Bramford to Twinstead Reinforcement

Document 8.3.2.2: Applicant's Written Summary of Oral Representations to Issue Specific Hearing 1

Final Issue A
September 2023

Planning Inspectorate Reference: EN020002

STOUR VALLEY EAST  
 CABLE SEALING END  
 COMPOUND AT LITTLE  
 CORNARD

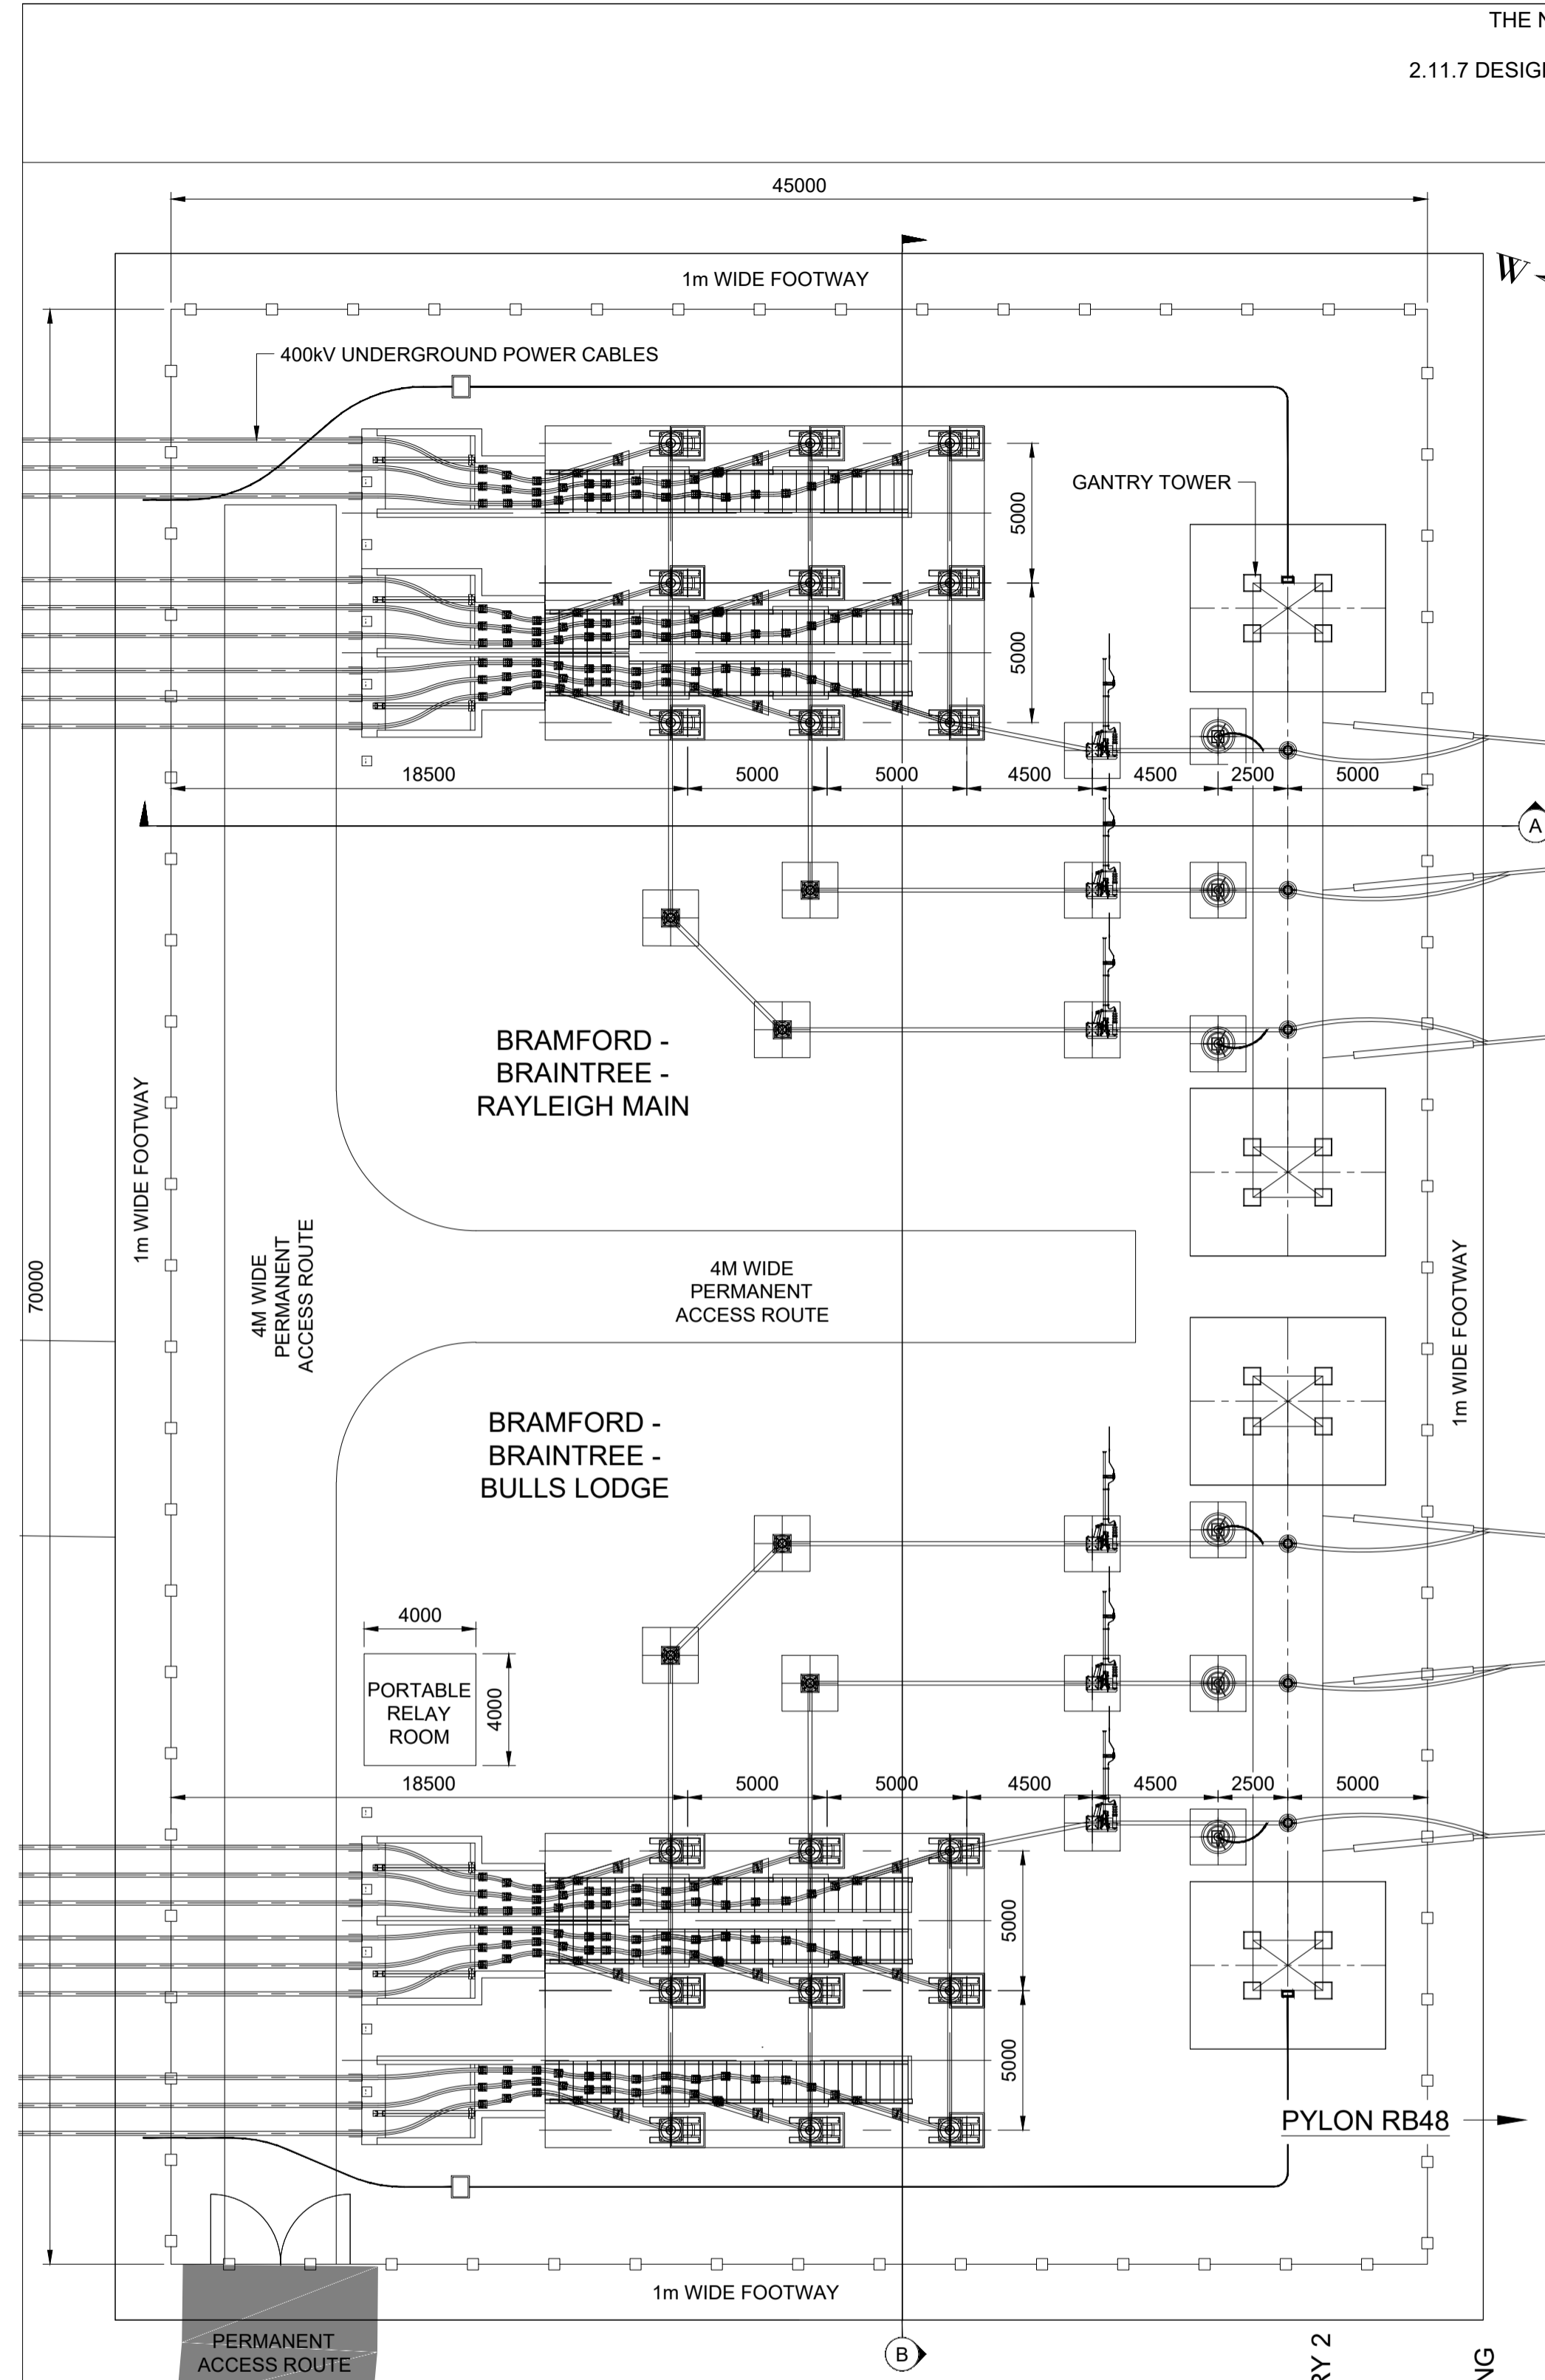
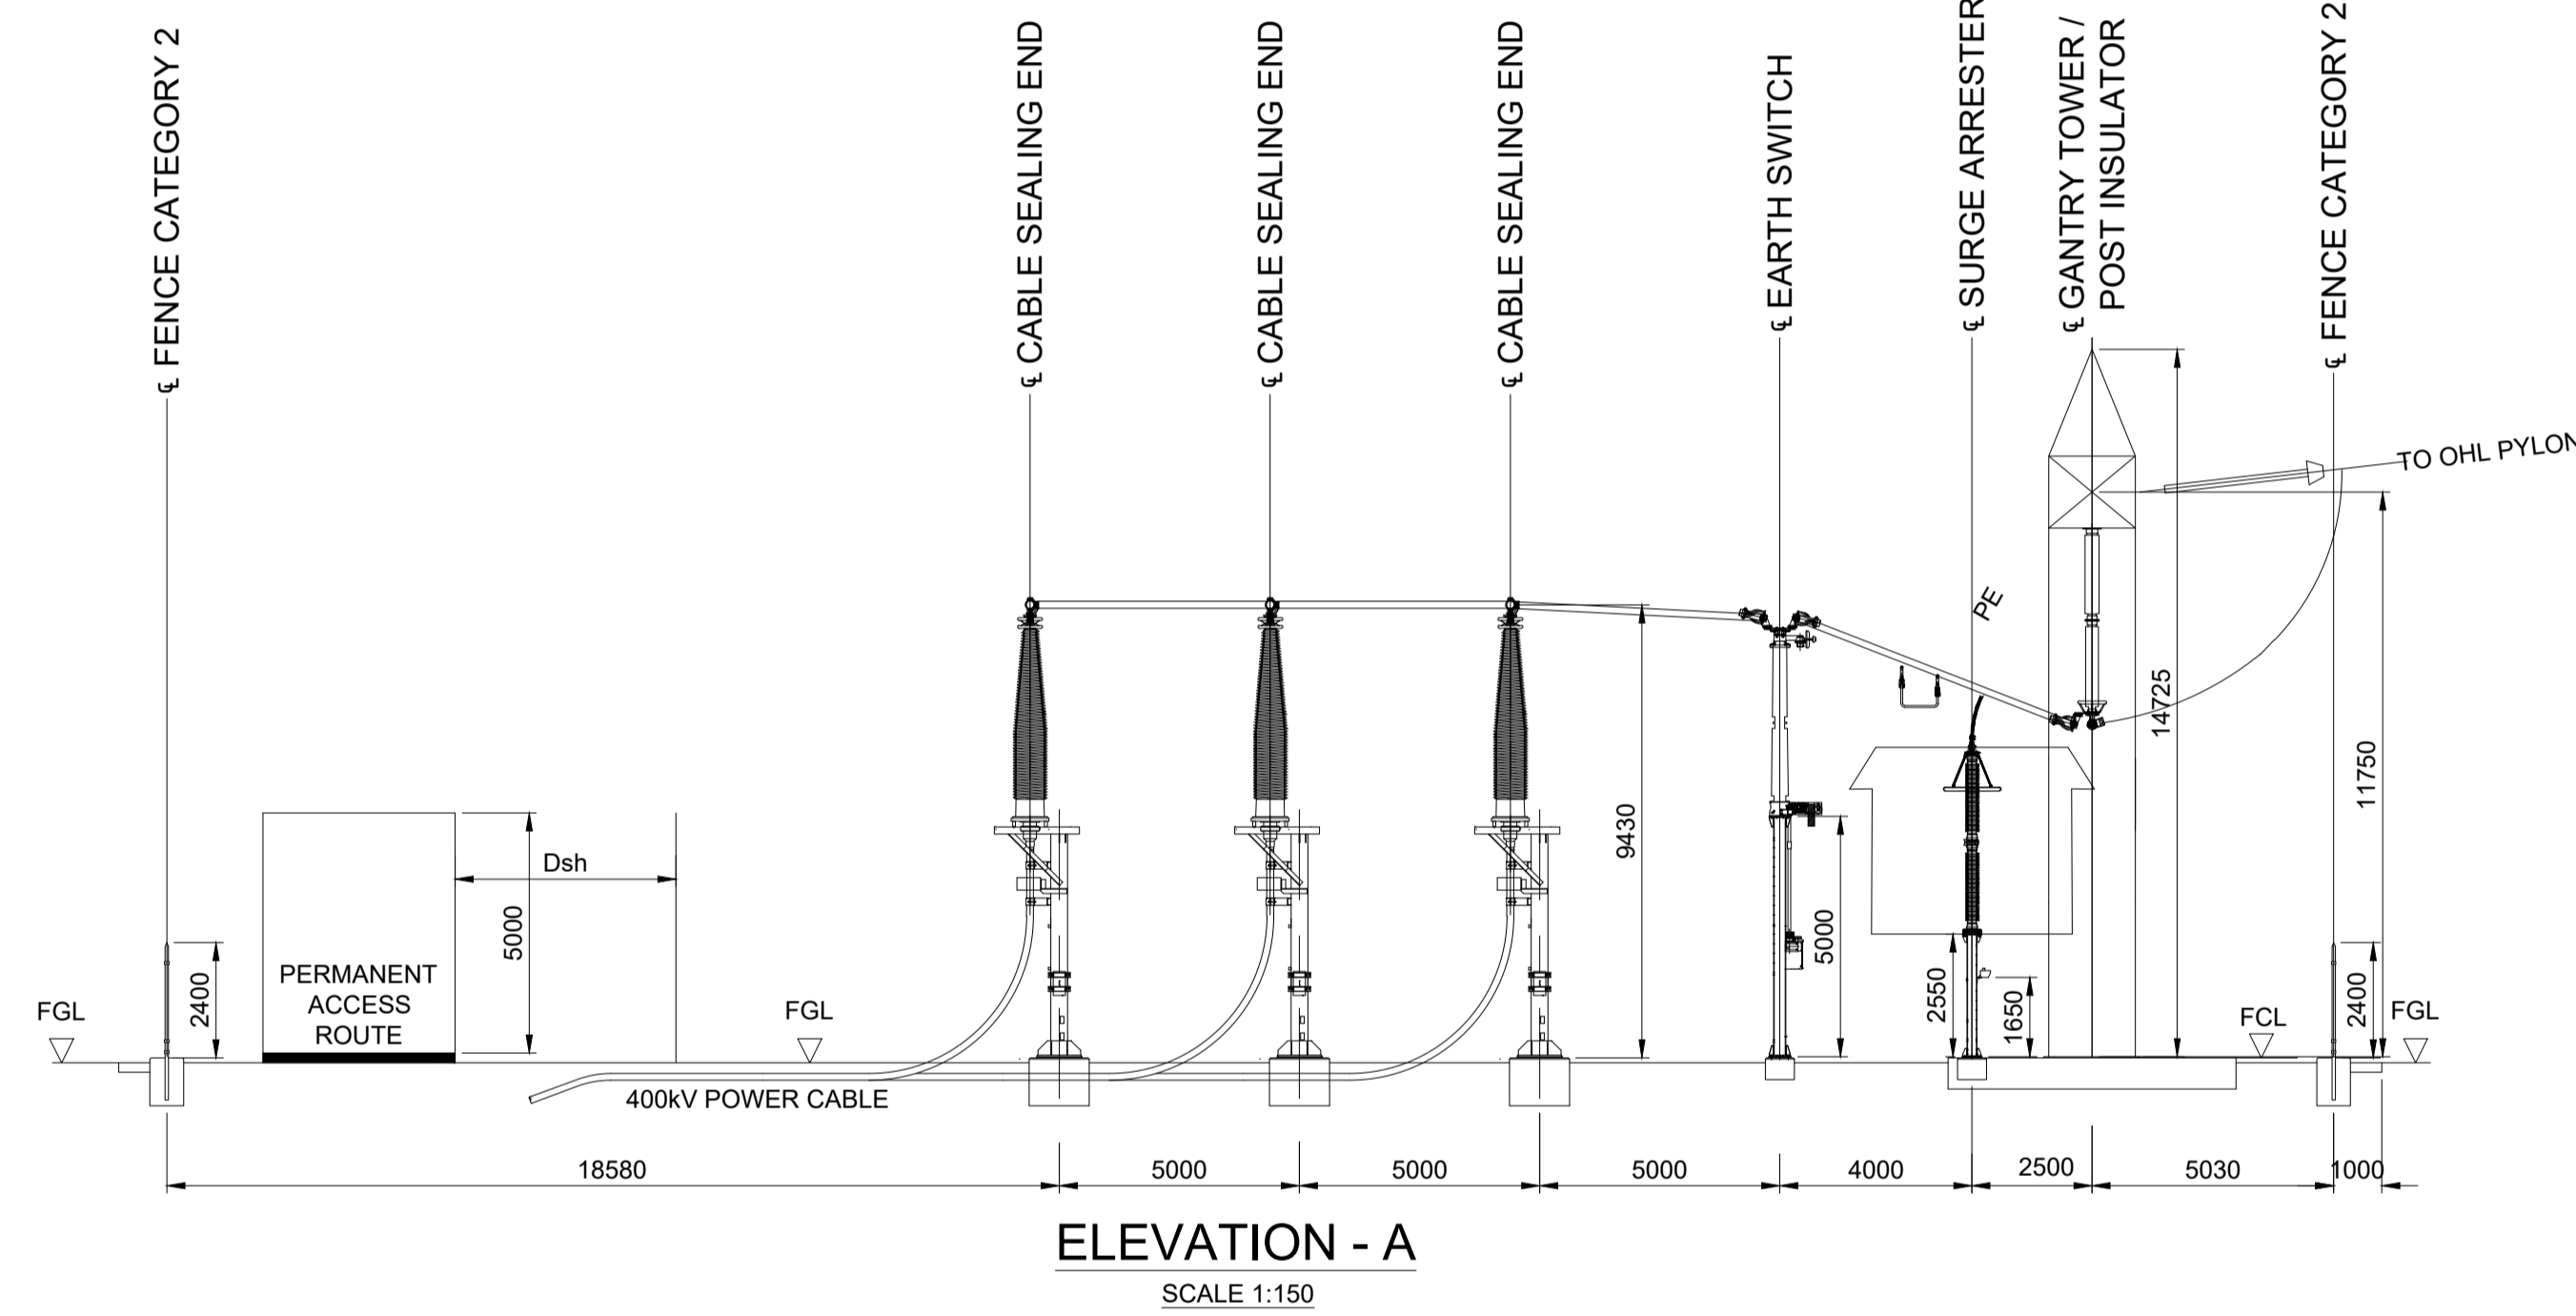
Stour Valley East CSE Compound

The equipment used within the CSE compound, as per Design and Layout Plans Stour Valley East Cable Sealing End Compound [APP-025], is in accordance with technical requirements and with other similar compounds utilised throughout the National Grid network. The size of the compound is circa 45m x 70m and is necessary to accommodate the required equipment and to provide a safe and secure compound throughout the asset life.

The LoD for the CSE compound are intended to allow the main works contractor, once appointed, some flexibility with the final positioning / layout of this compound. This assists with the detailed design of the compound and the interface positions between the underground cable and overhead line whilst at the same time constraining the position of the CSE compound within the area assessed.

The LoD have been derived by applying a 25m buffer zone on each side of the CSE compound dimensions, as per Design and Layout Plans Stour Valley East Cable Sealing End Compound [APP-025] which allows for the repositioning of the compound to suit final overhead line / underground cable alignments, or to relocate equipment items if needed to avoid unexpected ground conditions.

At the CSE Compounds the non-linear LoD and the linear LoD overlap to allow for all equipment to be accommodated within the LoD.
